**The RSPB's comments on the Addendum to  
the Without Prejudice Habitats Regulations  
Assessment Derogation Case**

**for the  
Royal Society for the Protection of Birds**

**Submitted  
15 May 2023**

**Application by Alternative Use Boston Projects  
Limited for an  
Order Granting Development Consent for the  
Boston Alternative Energy Facility**

Figure A2.1. Details of Wyberton Roads (North) – a) local levels across site, b) air photograph, c) general land levels.

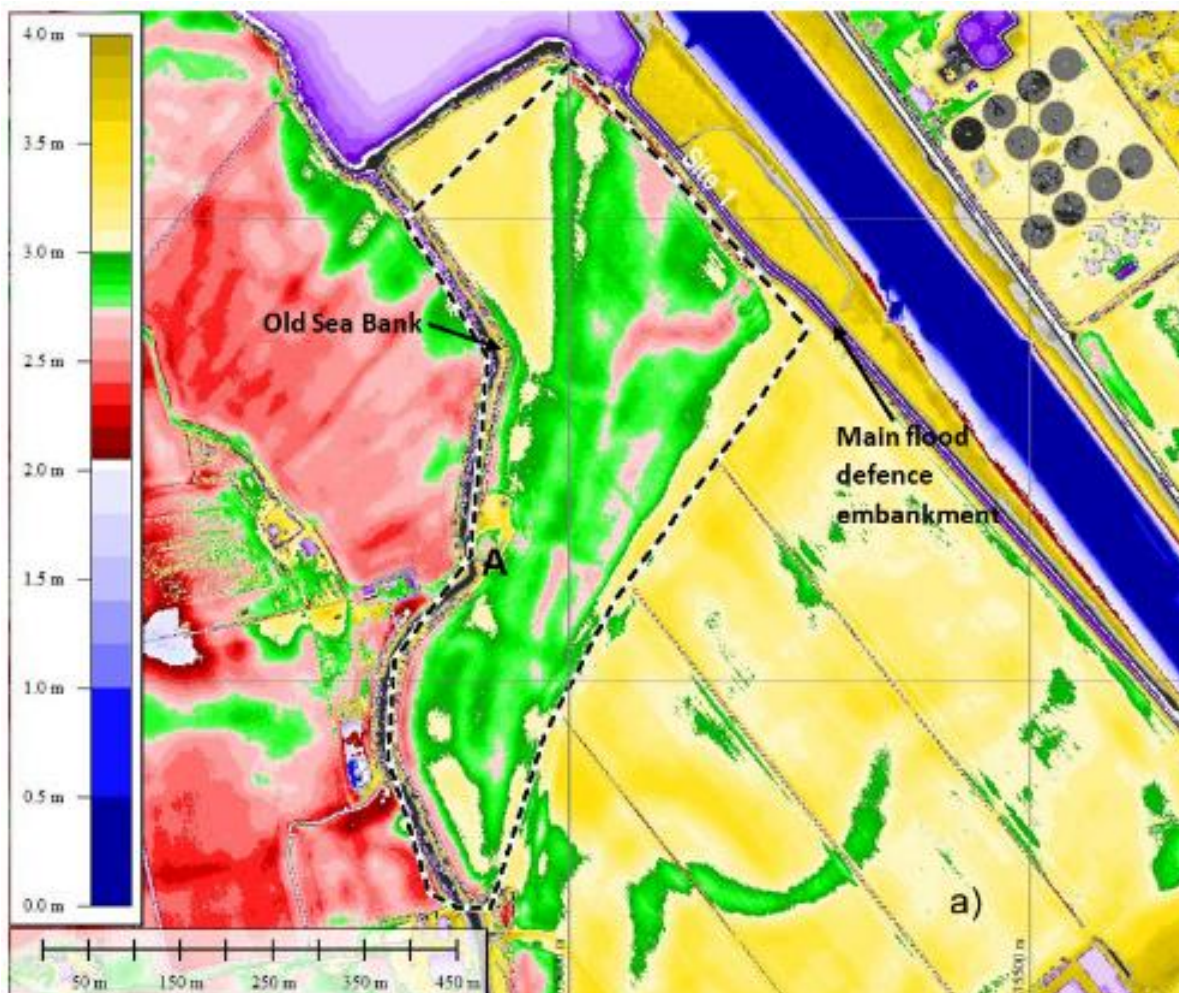
<p><i>particular, at Point "A" (shown in Figure A2.1a), there appears to be some separation of the back ditch, with the potential for diverting the northern length of the back ditch such that this section of ditch feeds into the "site valley" feeding water into the low-lying area behind the main flood embankment. The southern section of the back ditch would continue to flow to the south. Such works might be quite minor, merely encouraging accumulation of water within the site area.</i></p> <p><i>2.1.16 "The above works could be further enhanced by excavation along the line of the main site valley...such that the area of permanent areas of open water was encouraged, potentially forming a series of ponds, interspersed with areas of slightly higher ground (using excavated material) with no increased flood risk to the adjacent land. Within the overall site area there is potential for around 8 ha of freshwater habitat areas.</i></p>	<p>simplistic in its assumptions. Our experience of wetland creation is that simply having a ditch connection is not a guarantee that there will be sufficient water available for wetland creation and maintenance. There is no indication that conversations with the Internal Drainage Board have confirmed certainty of supply. There is also a need to understand water demand in the area, especially to assess how diverting any water from the drainage ditch could affect existing habitat at the end of the drainage network, such as at Frampton Marsh. Hydrological assessments must be undertaken to determine whether any water storage may be needed to support maintenance of the habitat in the future. This is particularly important when set against recent drought conditions and the predicted water deficits set out by Water Resources East in their draft Regional Water Strategy<sup>2</sup>. The Applicant must be able to demonstrate that suitable infrastructure will be in place to manage water supply not just now but also in the longer term. This may require a water storage reservoir to be constructed, as we have at Frampton Marsh. Construction of a reservoir will use land and impact on the overall level of compensatory habitat that could be created. There would also be additional planning and consenting requirements that need to be demonstrated that they could be met.</p> <p>Whilst we accept the site could be suitable as a compensation site, there remains significant detail not provided by the Applicant to provide confidence that the technical requirements of the site can be achieved.</p>

Figure 2-6 Search area and three candidate locations for additional rock revetments roosting area situated away from The Haven shipping route

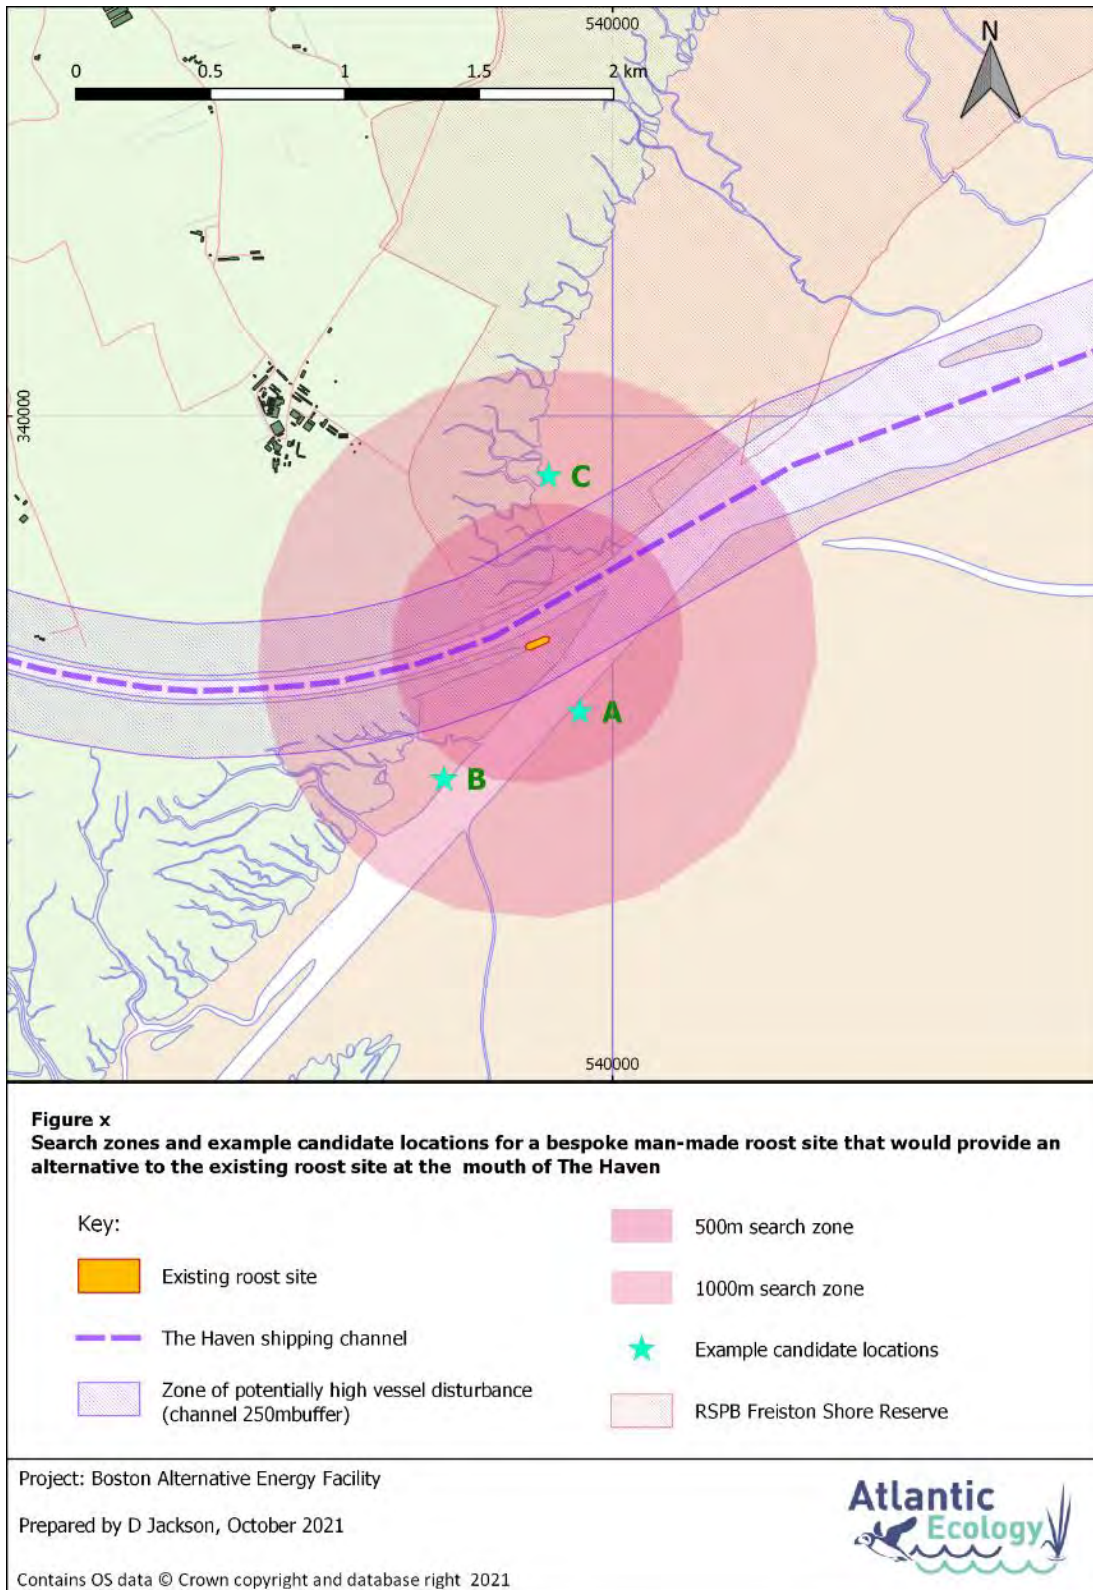
2.12. The Applicant has identified three locations where rock groynes could be constructed to provide alternative roost sites for birds displaced by vessels, especially turnstones and oystercatchers. These would cover 0.35ha; the same area as the current rock groyne at the mouth of The Haven.

2.14. The proposed areas identified for the rock groynes are within The Wash SPA/Ramsar and The Wash & North Norfolk Coast SAC. They would be deposited on areas of intertidal habitat that are protected in their own right, or as supporting features of the SPA/Ramsar or SAC. Based on Wetland Bird Survey data we know that large numbers of birds use the intertidal habitat at the mouth of The Haven, with mudflat in the area being some of the last to be covered at high tide. Consequently, the area is of high conservation value. Any placement of rock would therefore result in the loss of existing foraging habitat and have a potential displacement effect. The suggested impact of 0.35ha of The Wash SPA/Ramsar fails to consider the wider impacts associated with such a measure. The scale of impact of this proposed measure is therefore underestimated and not accurately reflected in the Applicant's 'Addendum

- The placement of rocks would have an impact on the intertidal processes. No information has been presented to assess erosion impacts from scouring. Where the rocks protect areas from being overtopped this will allow saltmarsh to develop and impact on the potential extent of mudflat. The potential changes in habitat arising from such changes have not been considered by the Applicant.
- The Welland navigation channel may be impacted by the placement of additional rocks, as a higher rock groyne would prevent water overtopping the rocks, as currently occurs on high tides. No assessment of the impact of constraining the flow of water at high tide in the Welland channel has been considered.

<b>Location</b>	<b>RSPB response and suitability</b>  <b>Green</b> – Suitable <b>Amber</b> – Potentially suitable but outstanding concerns <b>Red</b> – Not suitable
Compensation Site A	We are aware that there is already a rock groyne in place in this area. It is overtopped at high tide. The Applicant has provided no baseline data to inform the existing ecological importance of this location. There is also no detail on the anticipated height that the rock groyne would need to be extend above high tide levels and support the predicted number of birds displaced. The Applicant would also be required to assess the effect that a more substantial rock groyne in this area would have on water flow and surrounding sediments. For example, would water be displaced and result in erosion of intertidal habitat, would a more protected area behind the rock groyne increase transition to

<p>saltmarsh and therefore reduce mudflat foraging area, would there be impacts on the Welland navigation channel? All of these issues need to be addressed in order to determine that this approach would be appropriate.</p> <p>Based on the lack of information to support this proposal and the direction provided by the current Defra guidance, we do not consider this an appropriate site for considering as an alternative high tide roost.</p>
Compensation Site B	<p>This site is located in an area already used by roosting oystercatchers at high tide. Given the fact that this is already used as a high tide roost, we question the benefit that would be derived of adding rocks to this location. No assessment is provided to understand the current ecological importance of the site or understand the impact of adding rocks to this location.</p> <p>For the reasons above, this site is not appropriate for consideration as an alternative high tide roost.</p>

Compensation Site C	<p>This is located within the RSPB's Freiston Shore reserve (see Appendix 1). <b>The Applicant has not discussed this option with the RSPB.</b> If the Applicant had approached us we would have refused permission. We are disappointed that a proposal has therefore been submitted for public scrutiny without having first consulted the landowner and site manager.</p> <p>The location is also in an area heavily used by black-tailed godwits and other waders. These birds would be displaced away from the foraging area. Any rock placed in this area would therefore impact on an area of The Wash SPA/Ramsar that provides optimum feeding conditions and would therefore need to be compensated due to displacement of foraging and roosting waders. The position of the rocks high up the intertidal area will also result in habitat that is the last to disappear at high tide being lost to foraging waterbirds. This location demonstrates precisely why we do not consider compensation measures being sited with The Wash SPA/Ramsar to be acceptable.</p> <p>For the reasons above, this site is not appropriate for considering an alternative high tide roost.</p>
